Permit Inspections Harnett County

Permit Number: **BCOM2204-0002**

Description: **16 x 20 freestanding platform for church**

Site Address: **2160 HARNETT CENTRAL RD**

Foundation Details Peter Wallace Project

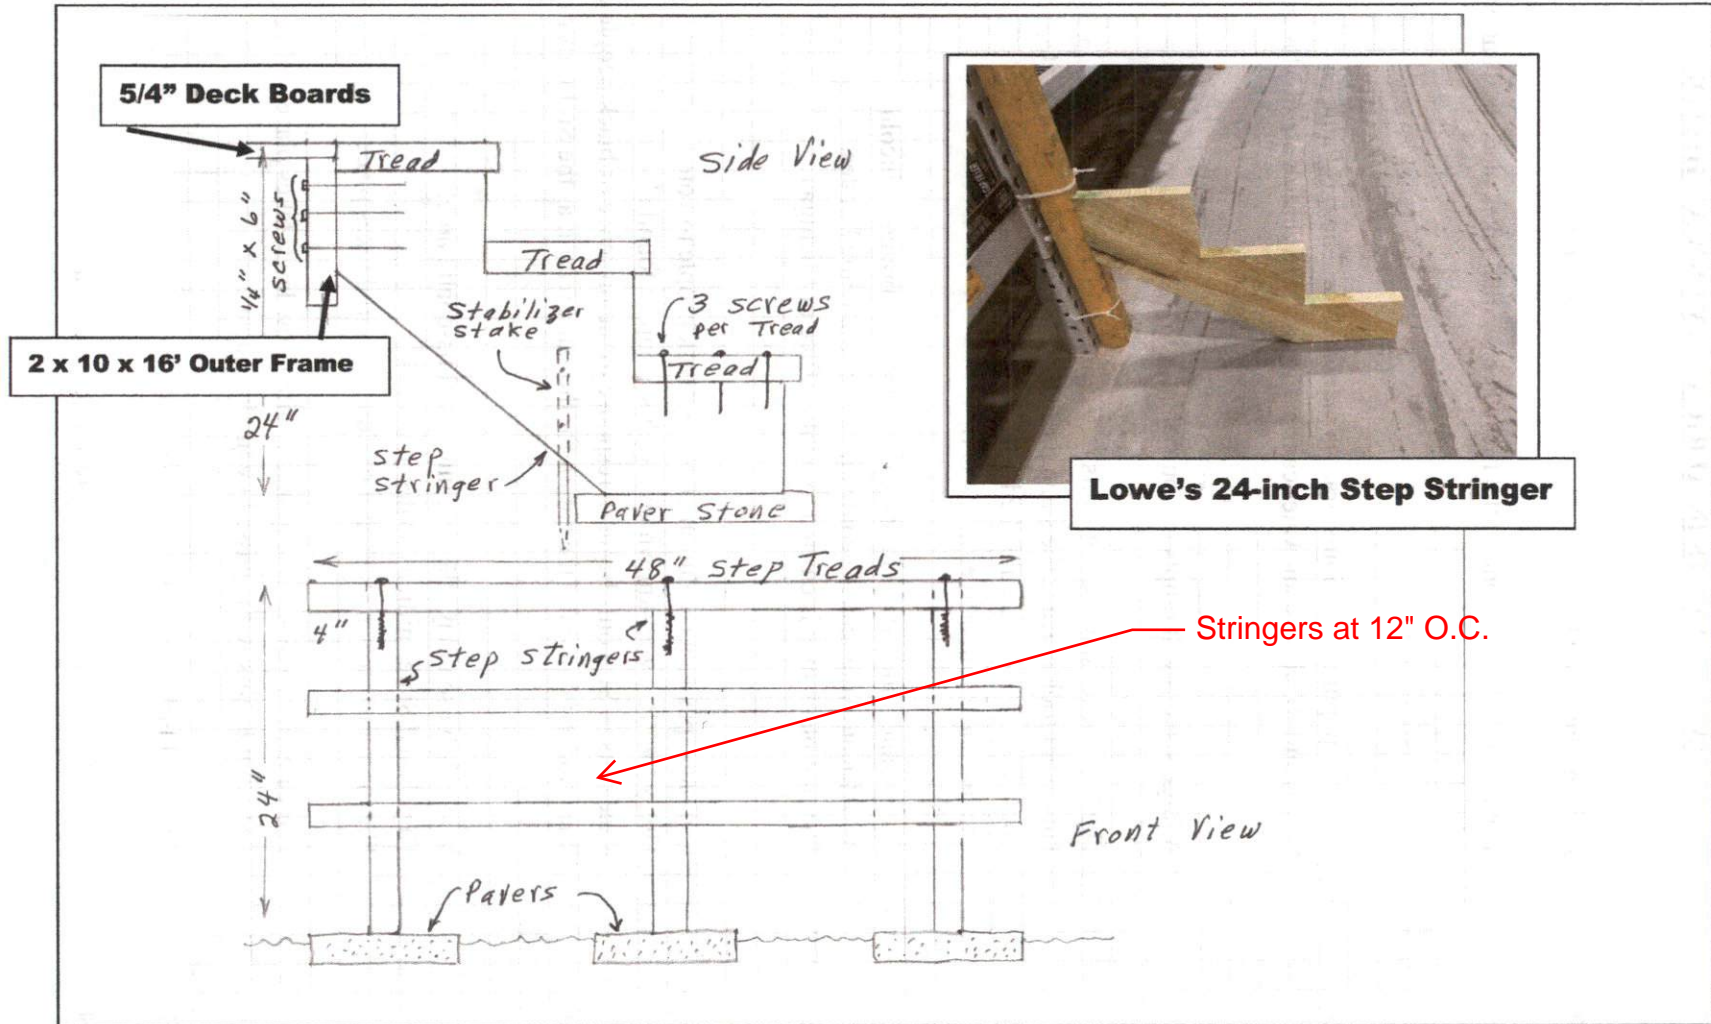
SEQ ID	SCHEDULED DATE	COMPLETED DATE	TYPE	INSPECTOR	RESULT	REMARKS
			ZONING	Planning Bucket		
Notes:						
			FINAL**	Unassigned		
Notes:						
	5/18/2022	5/18/2022	FOOTING	Scott Guy	APPROVED	
Notes: would like am inspection if possible						
	5/20/2022	5/23/2022	OPEN FLOOR	Scott Guy	APPROVED W/EXC	
Notes: Add member to end girders						
	7/7/2022	7/7/2022	FINAL**	Scott Guy	DISAPPROVED	
Notes: Handrail for steps is required with more than three steps.
